SSD 7382 UTS Central, Broadway Precinct

Detailed Response to Submissions – July 2016

DEVELOPMENT APPLICATION 3:00pm Shadow

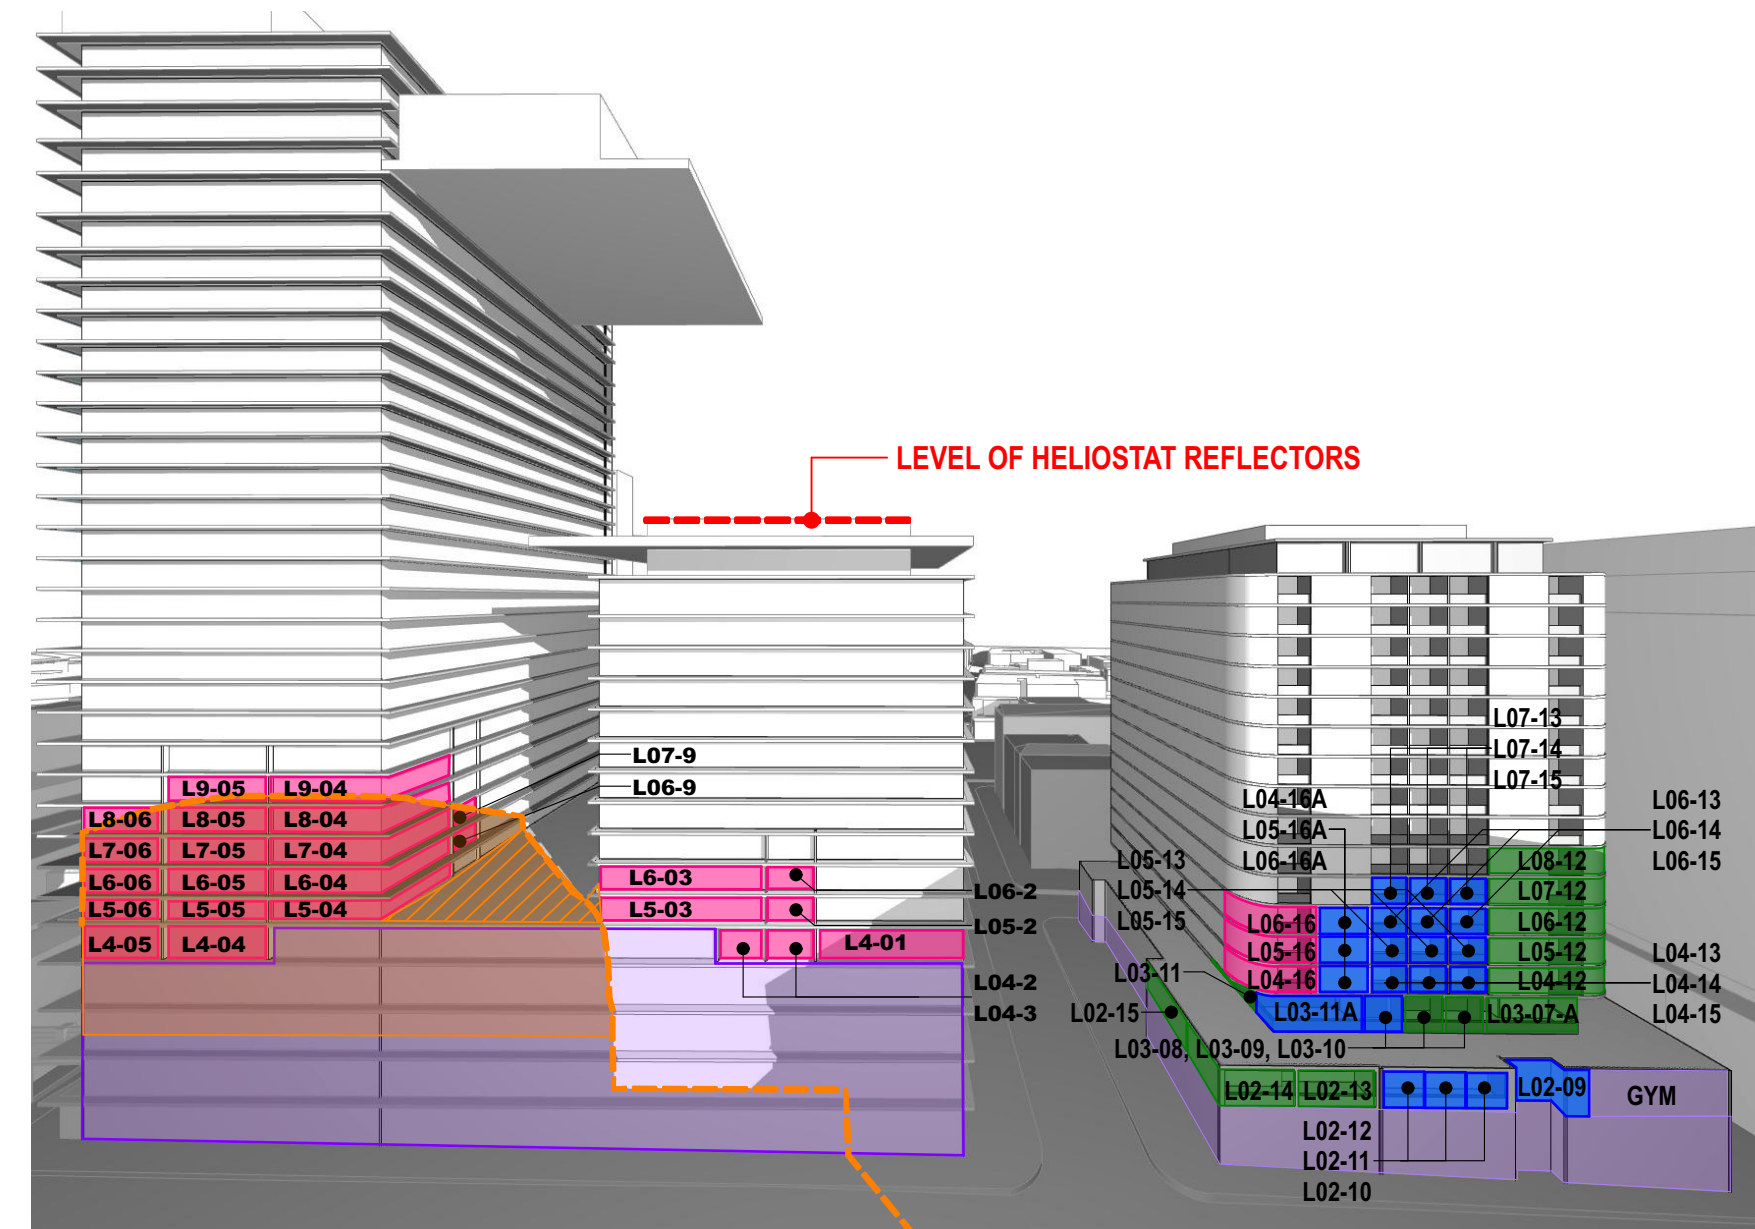
<p>Environmental and Residential Amenity</p> <p>5. The Department is concerned with the overshadowing impacts from the proposed building on the residential properties within Central Park and a further quantitate analysis of solar access to be retained and lost for all dwelling impacts by the proposal must be provided, including additional analysis of whether the proposal would impact on any heliostat solar collectors for building within Central Park.</p>	<ul style="list-style-type: none"> - FJMT and JBA have completed a detailed analysis on the overshadowing impact from the proposed building on the residential properties within Central Park as outlined within the main report. - The holistic assessment of the various amenity considerations for Block 1 demonstrates that notwithstanding the lower achievement of direct sunlight access, Block 1 will deliver a high level of residential amenity. - The proposed development is the same height as the lower tower of No. 1 Central Park and does not impact on the roof level of the lower tower where the reflectors are located or the roof level of the higher tower where the heliostat is located.

Solar & Daylight Access <p>In order to demonstrate that the proposed development is able to comply with Objective 3B-2 of the Apartment Design Guide and Section 4.2.3.1 of the Sydney Development Control Plan 2012, a solar analysis should be provided of the surrounding buildings and rooftop on which the heliostat solar collectors are located. A daylight report and LUX level map of affected apartments should also be submitted.</p>		<ul style="list-style-type: none"> - Detailed elevational shadow diagrams for Central Park (One Central Park and Block 1) have been prepared by FJMT (Attachment B) for June 21 (7.30am to 3pm) illustrating: <ul style="list-style-type: none"> - Shadows Cast by the modified Concept Plan (MOD 5 envelope) - Shadows cast by UTS Central SSDA. - Further, the existing building shadows cast over Central Park have been previously prepared and are also submitted with this report. - The proposal has been reviewed against the following: <ul style="list-style-type: none"> - <i>Objective 3B-2 of the Apartment Design Guide.</i> - <i>Section 4.2.3.1 of the Sydney Development Control Plan 2012.</i> - As outlined within the main report, the holistic assessment of the various amenity considerations for Block 1 demonstrates that notwithstanding the lower achievement of direct sunlight access, Block 1 will deliver a high level of residential amenity.
